In the matter of appeal ABP-320916-24 (Galway County Council ref. 24/60845)

Long-Duration Energy Storage System (224-container Battery Energy Storage System) and Synchronous Condenser, Coolpowra, Co. Galway

Appeal	ABP-320916-24 — long-duration energy storage and synchronous condenser, on appeal from Galway County Council's refusal of 30 August 2024 (ref. 24/60845).
One project	Co-located and, on the applicant's own concession, functionally connected: this BESS; the Reserve Gas-Fired Generator (ABP-320095-24, s.37E); and the Gas-Insulated Switchgear substation and HV cables (ABP-320094-24, s.182A).
Applicant	Coolpowra Flex Gen Limited (and related entities).
Submitted by	Eamonn O'Hara, Neale, Killimor, Ballinasloe, Co. Galway
Date	June 2026

Drawing file: MAPS 27-03-26 / CPA-HAL-MP-XX-DR-PL-1000 P10 Master Plan Layout New Access Road.pdf

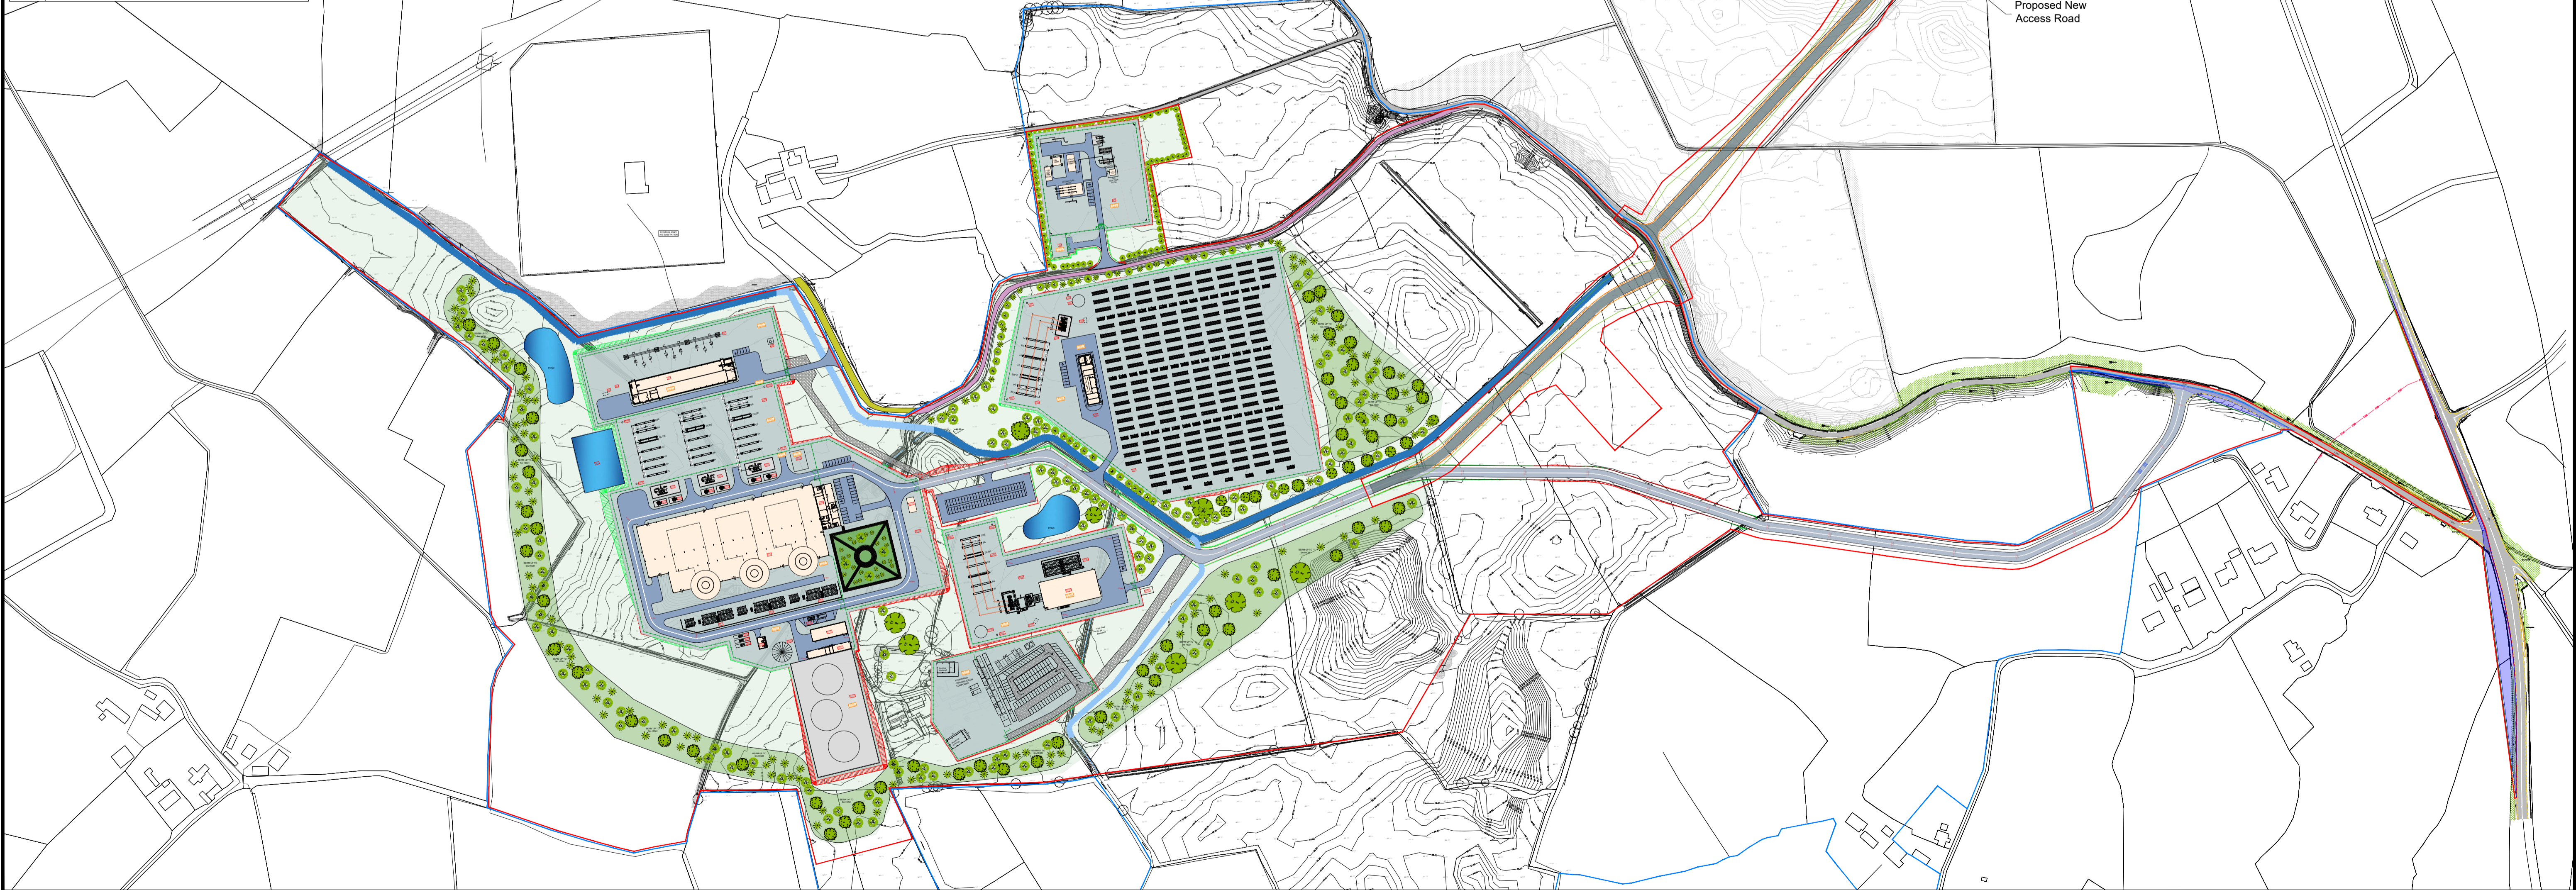
The applicant's response introduces a new construction access of approximately 810 m onto the N65 and a revised red-line boundary, stating the new access is “independent of third-party consent”; a footnote concedes the new access exists because the original junction's landowner sightline consents were withdrawn.

The deficiencies are these. Access onto a national road is a planning gateway: if the access is not permissible, the use of this site is not permissible, and no condition can cure it.

Most fundamentally, nothing has changed since the Council last refused development at this frontage. The adjoining frontage carries a settled refusal history over more than twenty years (Galway references 05/4009, 06/1200 and 08/2697), refused because adequate visibility could not be achieved without extensive intervention to the roadside hedgerow and the resulting development would constitute a traffic hazard. That hedgerow remains substantially intact and the road network is unchanged — so the very hazard the Council identified persists, and the historic refusal reasons apply with equal force to the present proposal. The applicant has not shown what has materially changed to displace those settled findings.
